OUT12/22403

11 SEP 2012

Response by Department of Primary Industries to the Environmental Assessment for Young-Wagga Wagga gas pipeline (MP10_0163)

Figure 6 – Dam and pump process

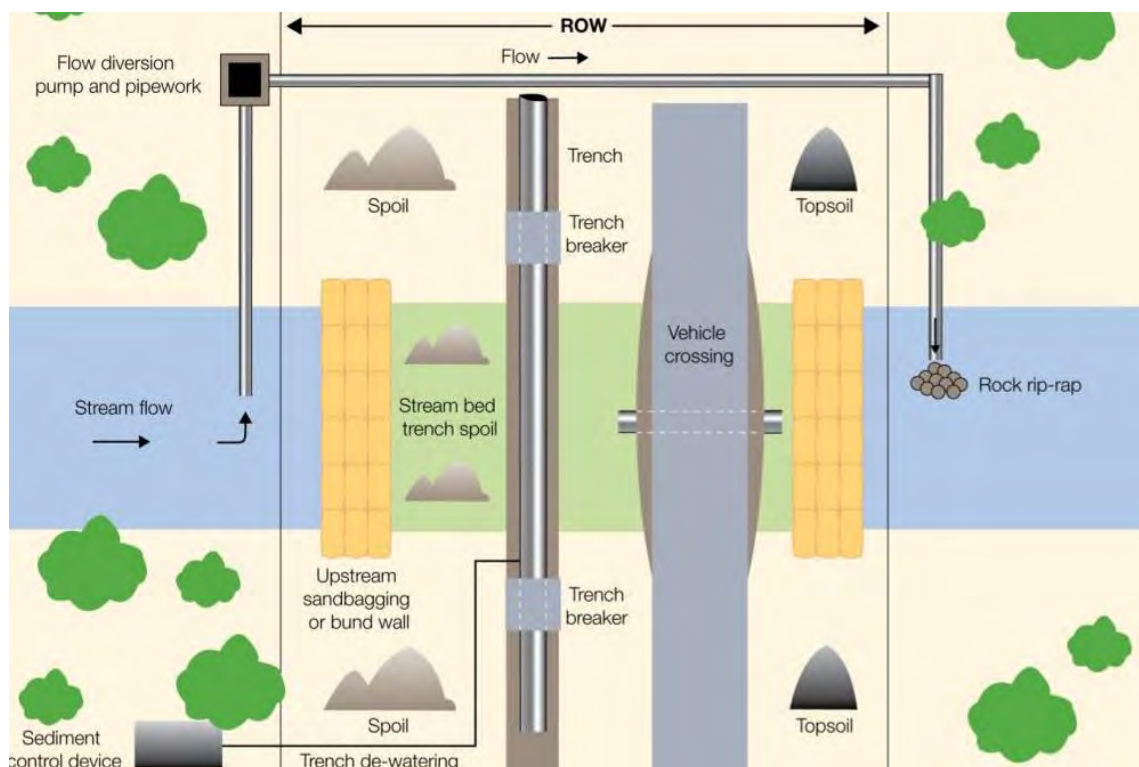
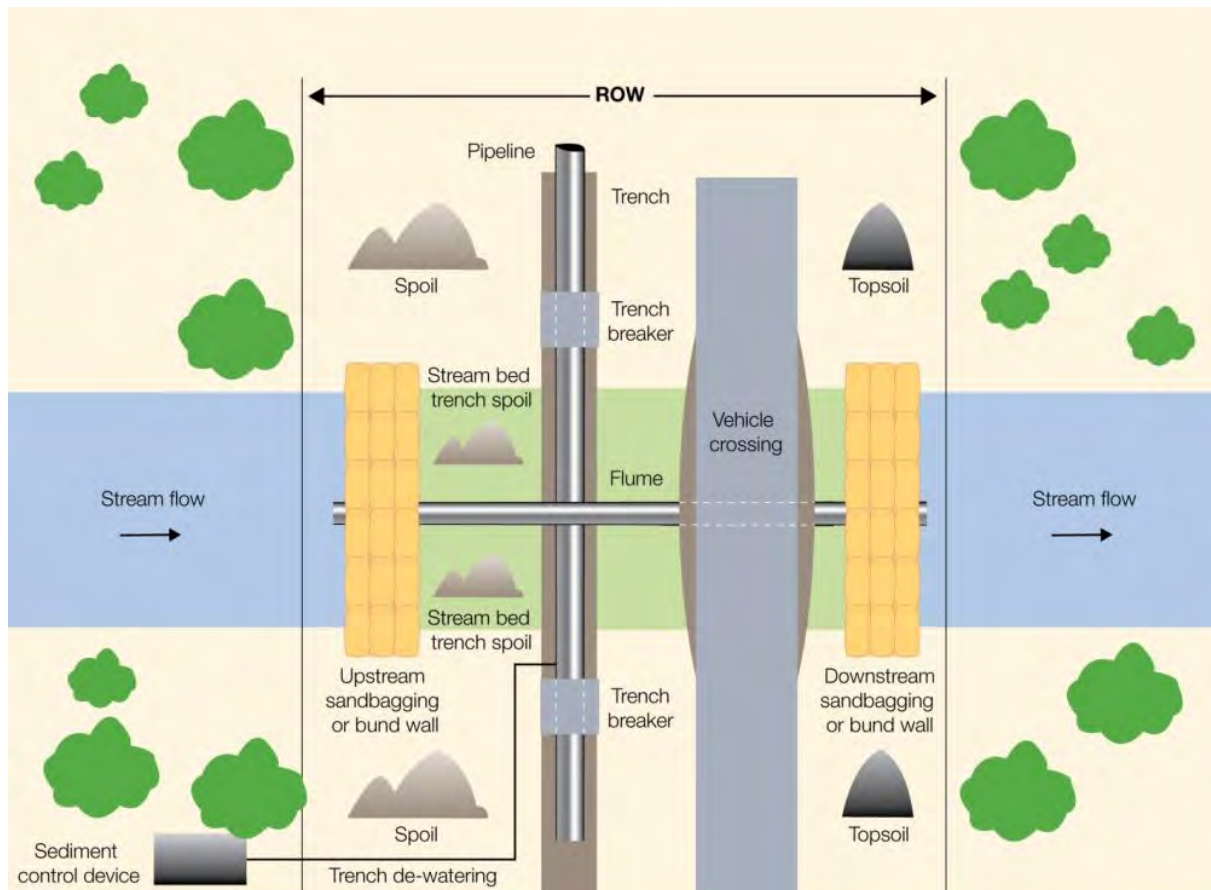
- the stranding of fish when the area between coffer dams is dewatered, and
- erosion of the pipeline corridor and discharge of sediment and turbid water into the waterway.

As such, the proposed Construction Environmental Management Plan (CEMP) needs to include a section on capturing and relocating any fish that may be stranded between coffer dams when waterway crossing sites are dewatered. The CEMP also needs to include details of arrangements for ensuring that erosion along the pipeline corridor is minimised and erosion and sediment controls are regularly checked and maintained until the corridor has revegetated and the risk of erosion and sedimentation is minimal.

3. The Construction Environmental Management Plan (CEMP) is to include an outline of procedures to cater for capture and relocation of any fish that may become stranded as a result of pipeline construction operations in waterway crossings.
